APPLICATION NO. 05DRB - 01538	PROJECT NO. 1004138
PROJECT NAME JOURNAL CENTER	
EPC APPLICATION NO.	9700
APPLICANT / AGENT MARK AYUWARD	PHONE NO. 761-4222
ZONE ATLAS PAGE D-17	
(SDP for SUB), (SDP for BP), (FINAL PLATS), (MASTER DEV PLAN), (IR), (AA)	
ONE STOP COMMENT FORM LOG

DRB CASE NO/PROJECT NO: 1004138

**CITY OF ALBUQUERQUE
PLANNING DEPARTMENT
May 11, 2005
DRB Comments**

RE: Tract 5, Journal Center/SPBP

SHEET NO.  
**A302**  
OF

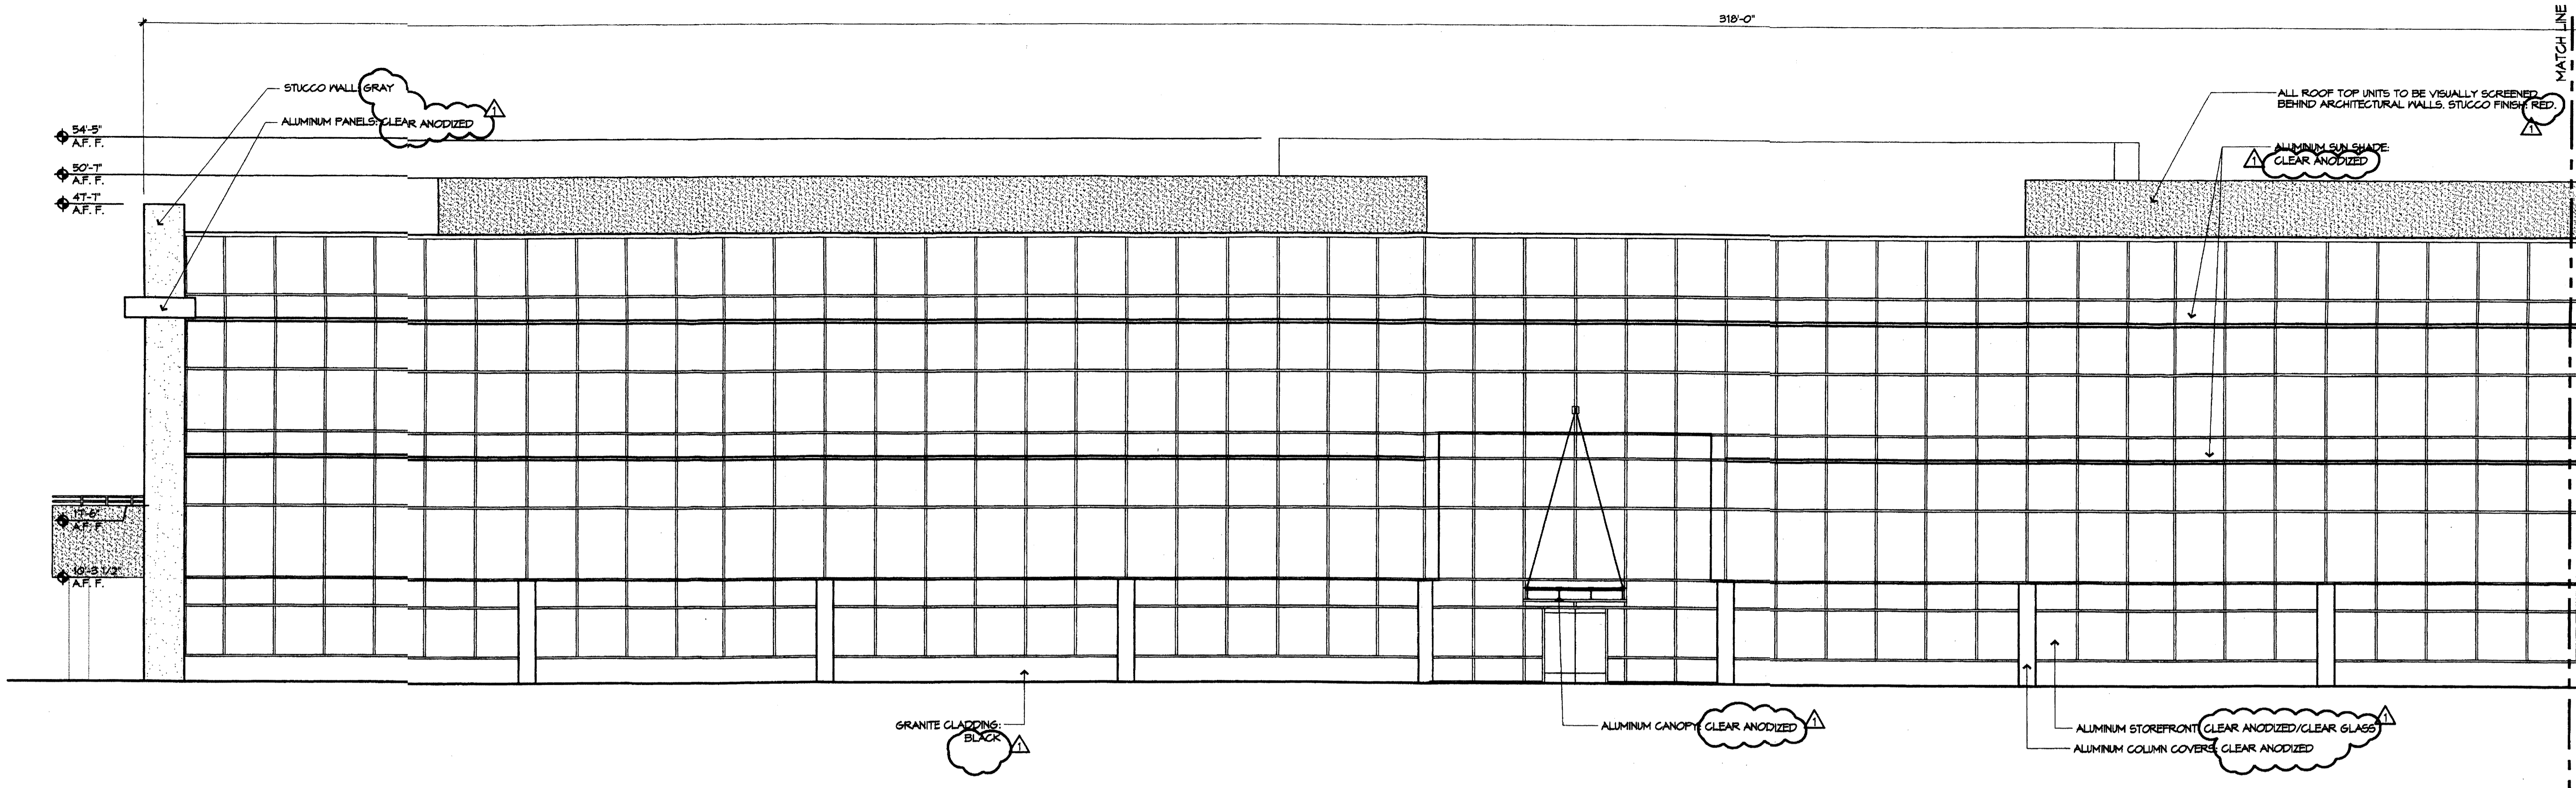
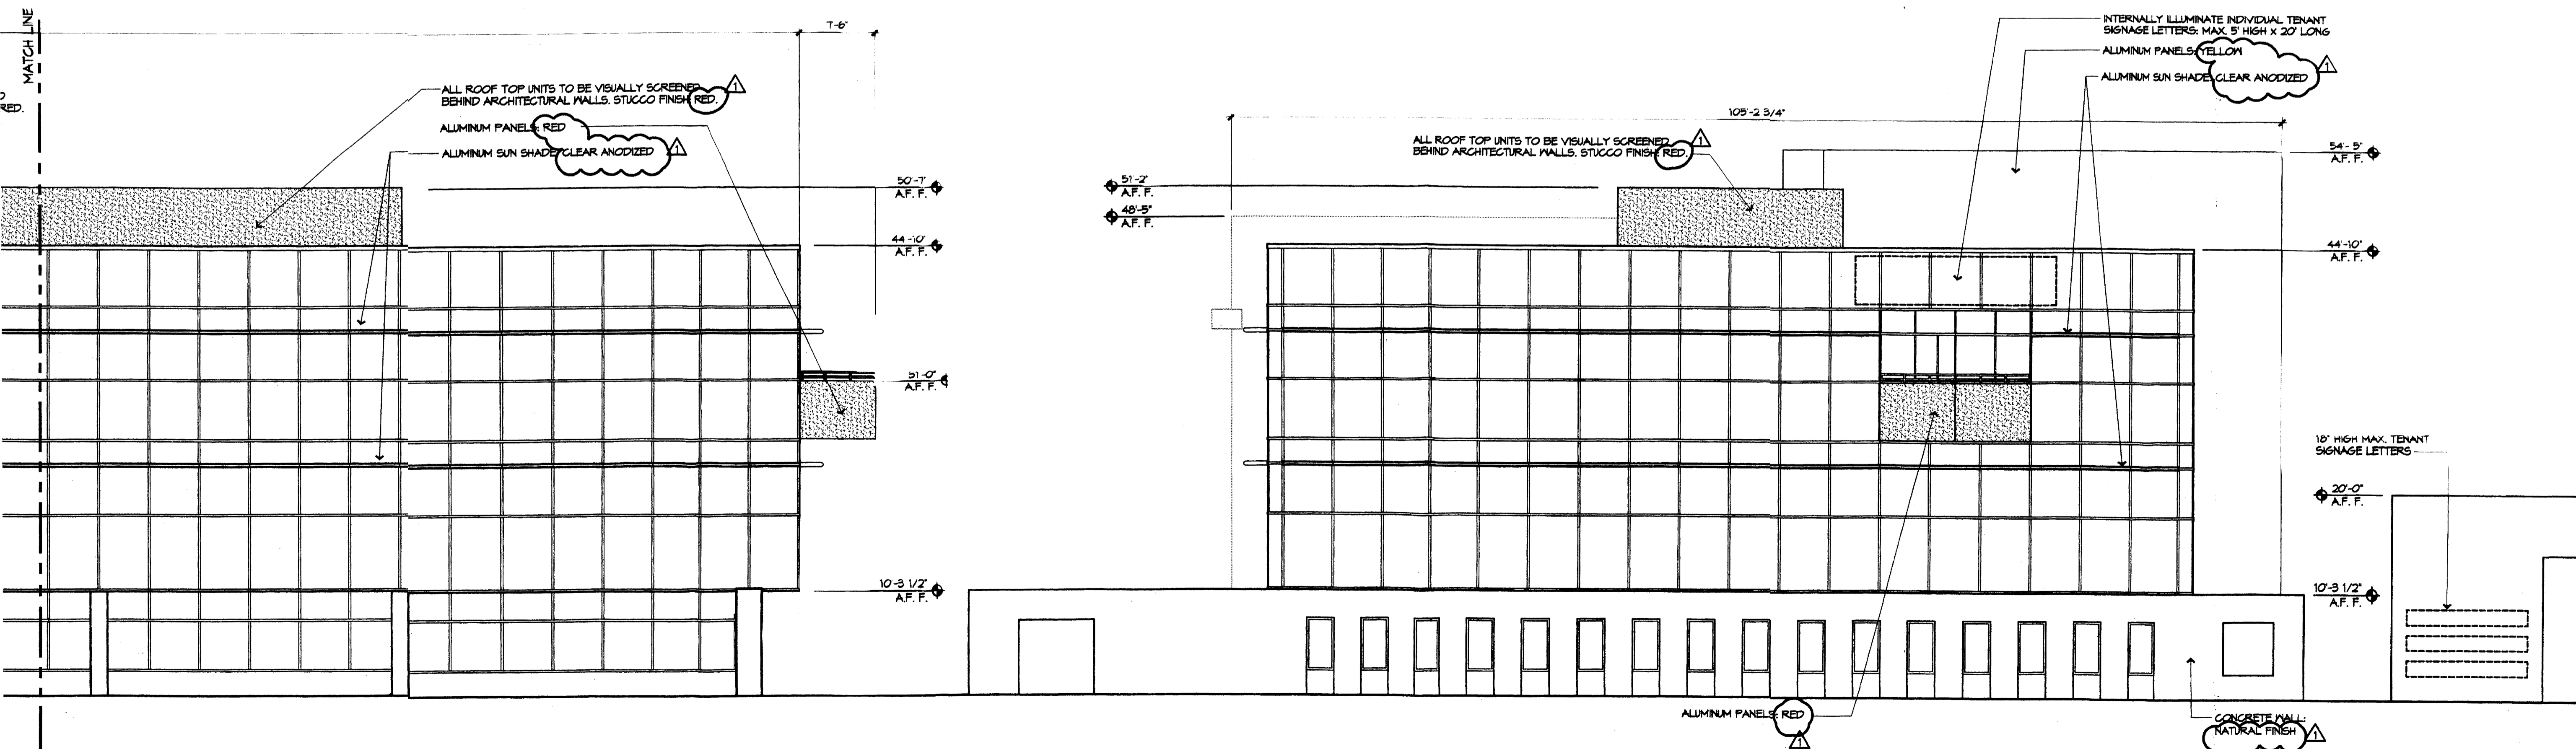
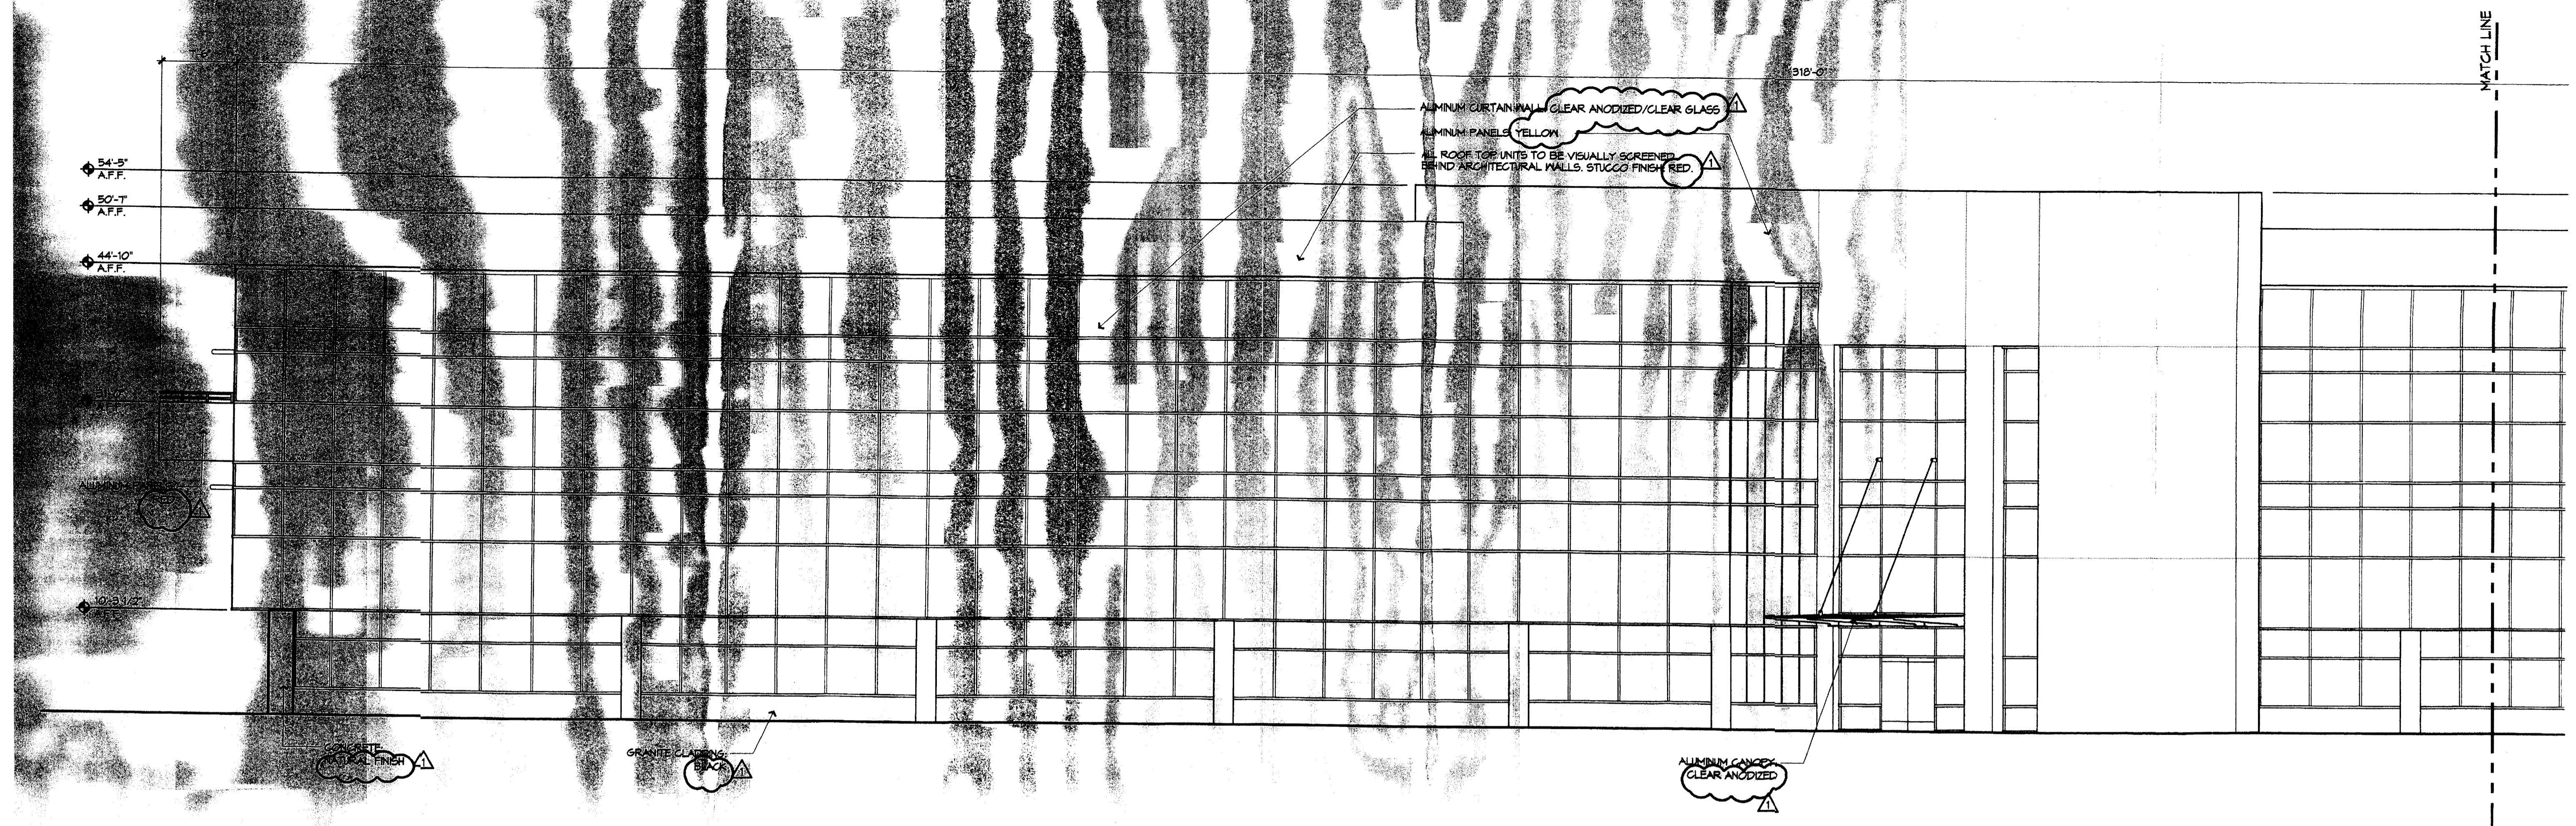
*✓ Who signed for Planning Director?
✓ Total width missing on Elevations
Sheet.*
